# CITY OF ALBUQUERQUE

December 8, 2023

**Re: Children's Promise Centers**  
**401 Alvarado Dr. NE**  
**30-Day Temporary Certificate of Occupancy**  
**Transportation Development Final Inspection**  
Architect's Stamp dated 08-04-22 (K18-D022)  
Certification dated 11-29-23

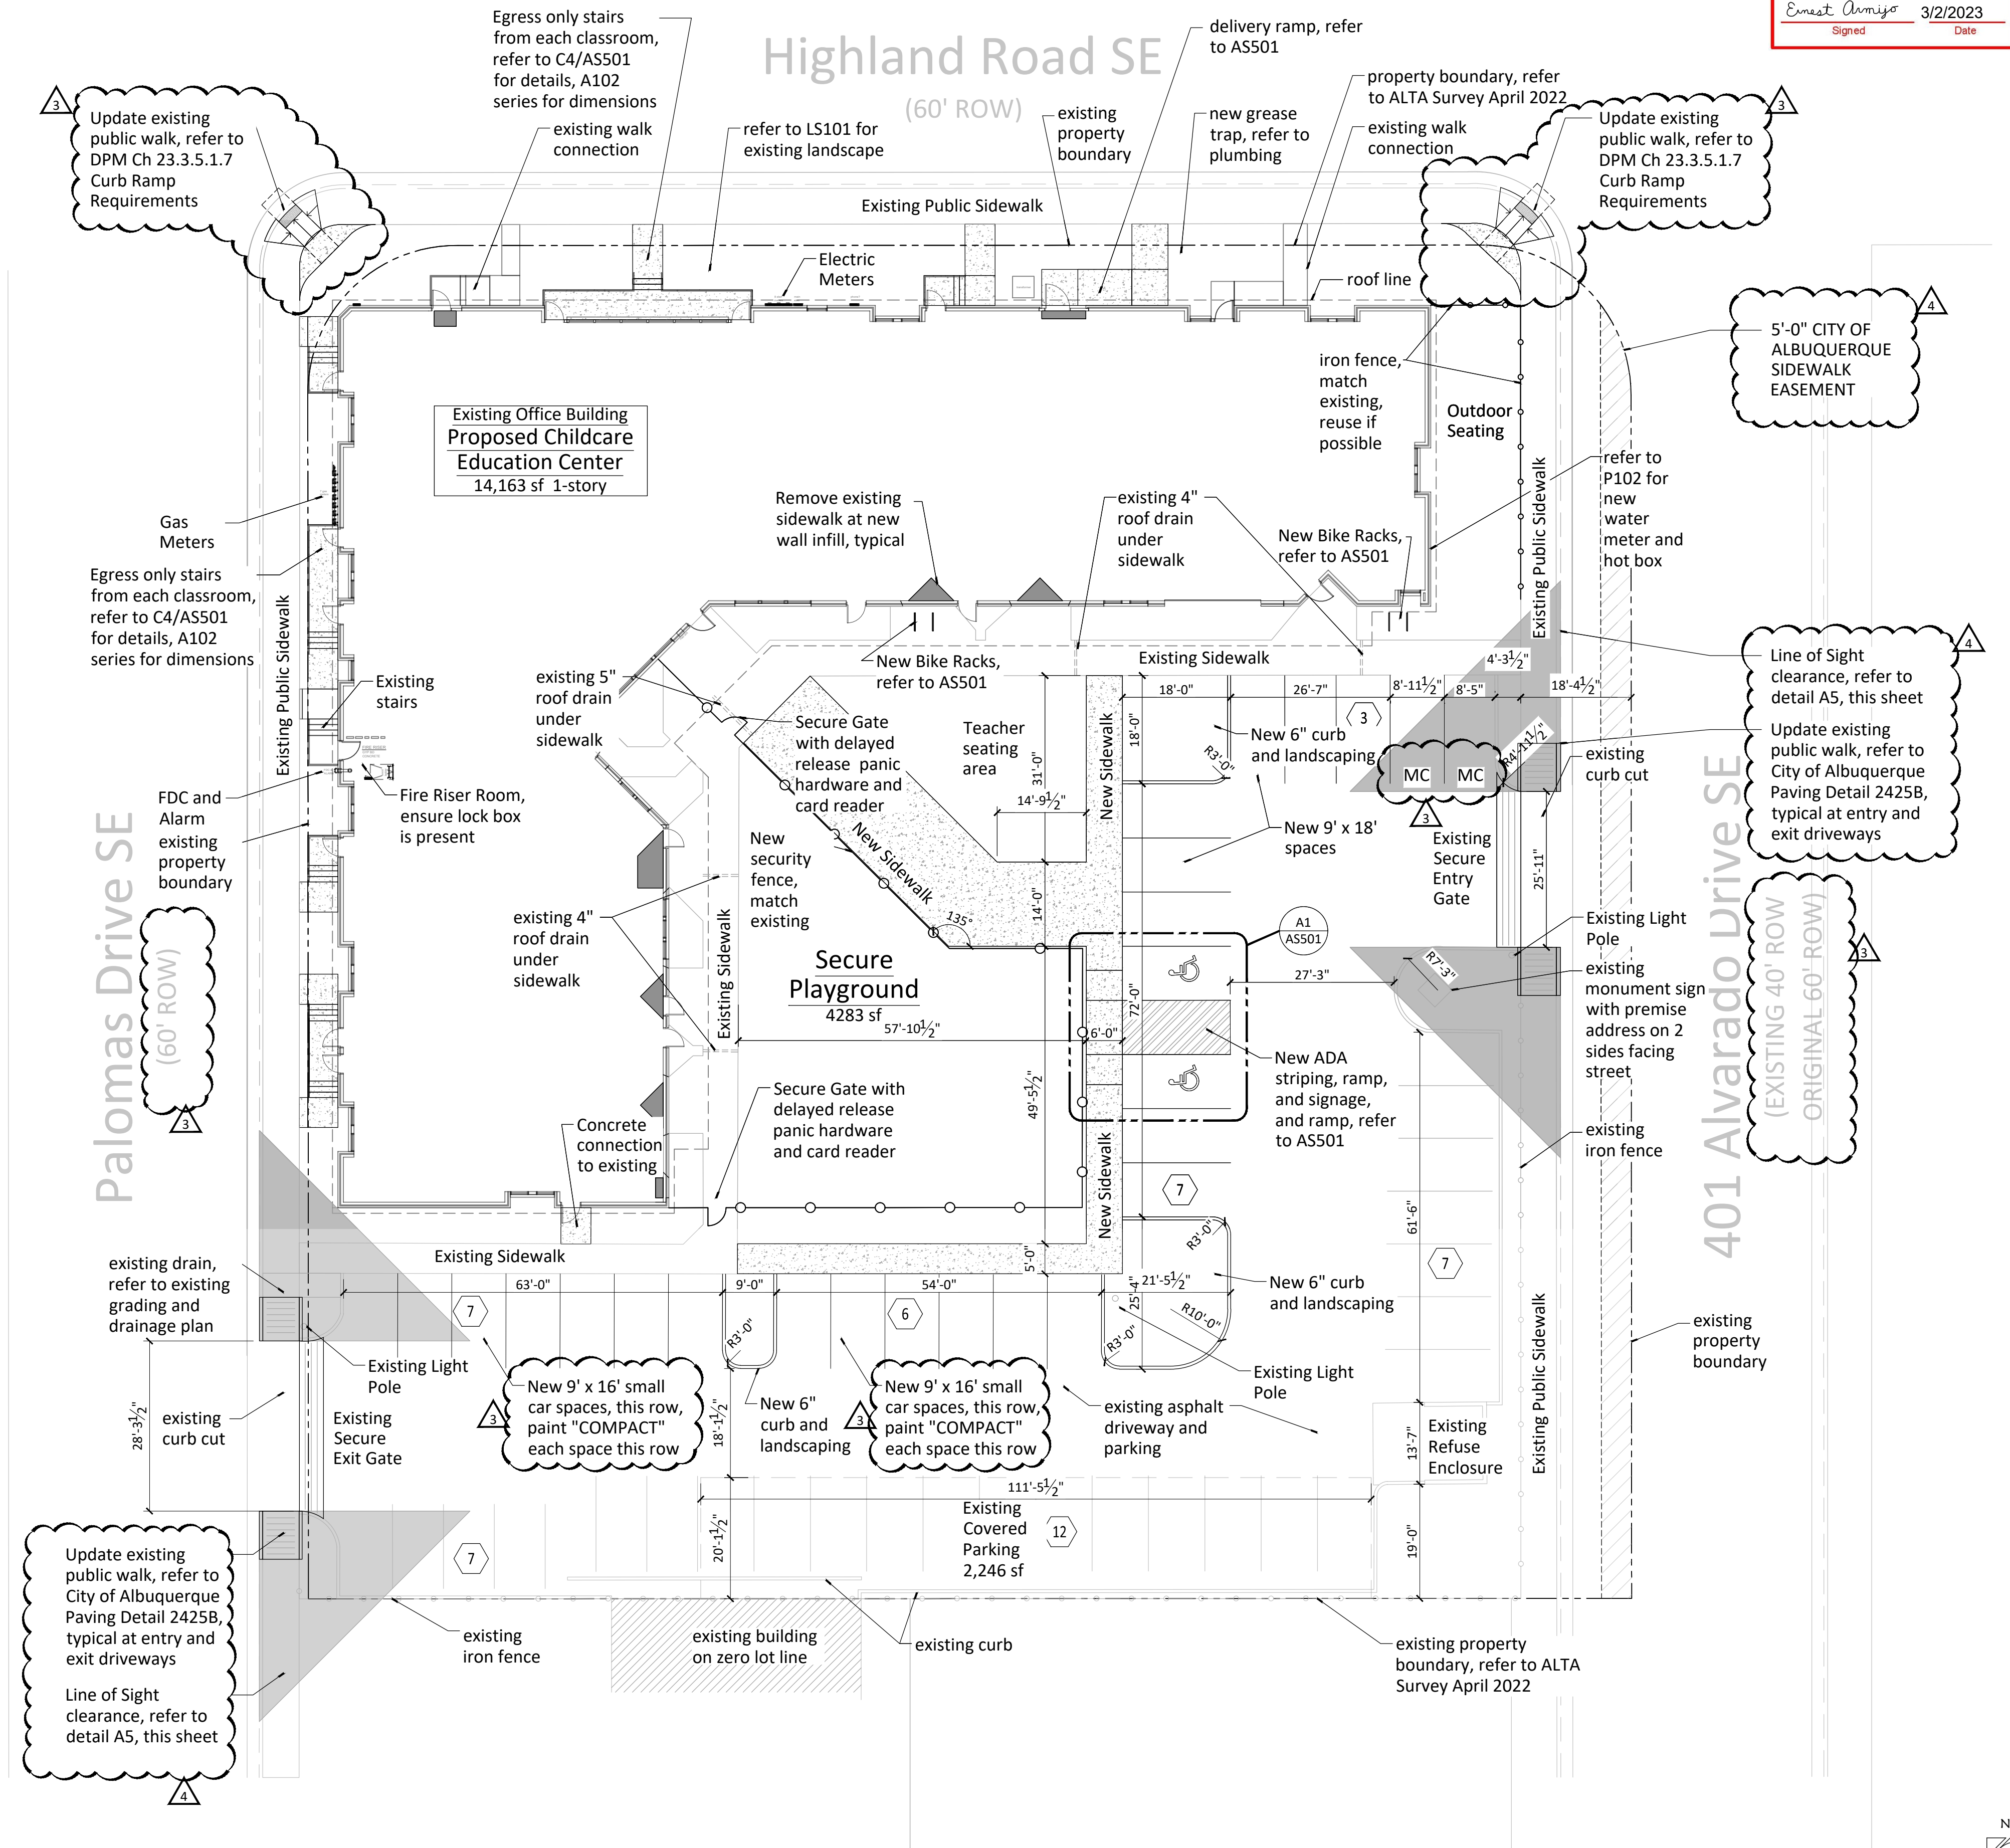
- Please review the approved plan dated on the Traffic Certification. The Architect Stamp is dated 08/04/22.
- Please fix the concrete cracked on the public sidewalk on the eastside of the site off Avarado Dr.

- The ADA accessible parking sign must have the required language per 66-7-352.4C NMSA 1978 **"Violators Are Subject to a Fine and/or Towing."**
- The ADA access aisles shall have the words **"NO PARKING"** in capital letters, each of which shall be at least one foot high and at least two inches wide, placed at the rear of the parking space so as to be close to where an adjacent vehicle's rear tire would be placed. (66-1-4.1.B NMSA 1978)
- Per site visit, this ramp does not comply with ADA standards. Please install an ADA compliant ramp that meet the ADA regulations (max. running slope should not exceed 8.2%).

- Site accesses and public ADA curb ramps at the corner of Alvarado & Highland Rd. and at Highland & Palomas Dr. must be updated to current standards and have truncated domes installed.
- Per approved site plan, please provide two Motorcycle parking spaces and the pavement marking "MC" should be shown in the opposite direction for motorcycles entering the parking space.
- Anchor down the bike rack.
- Tripping Hazard: sidewalk and landscape area at the south side of the playground must be at the same elevation.
- Please provide 6 ft. wide ADA pathway from the public sidewalk to the building entrance.
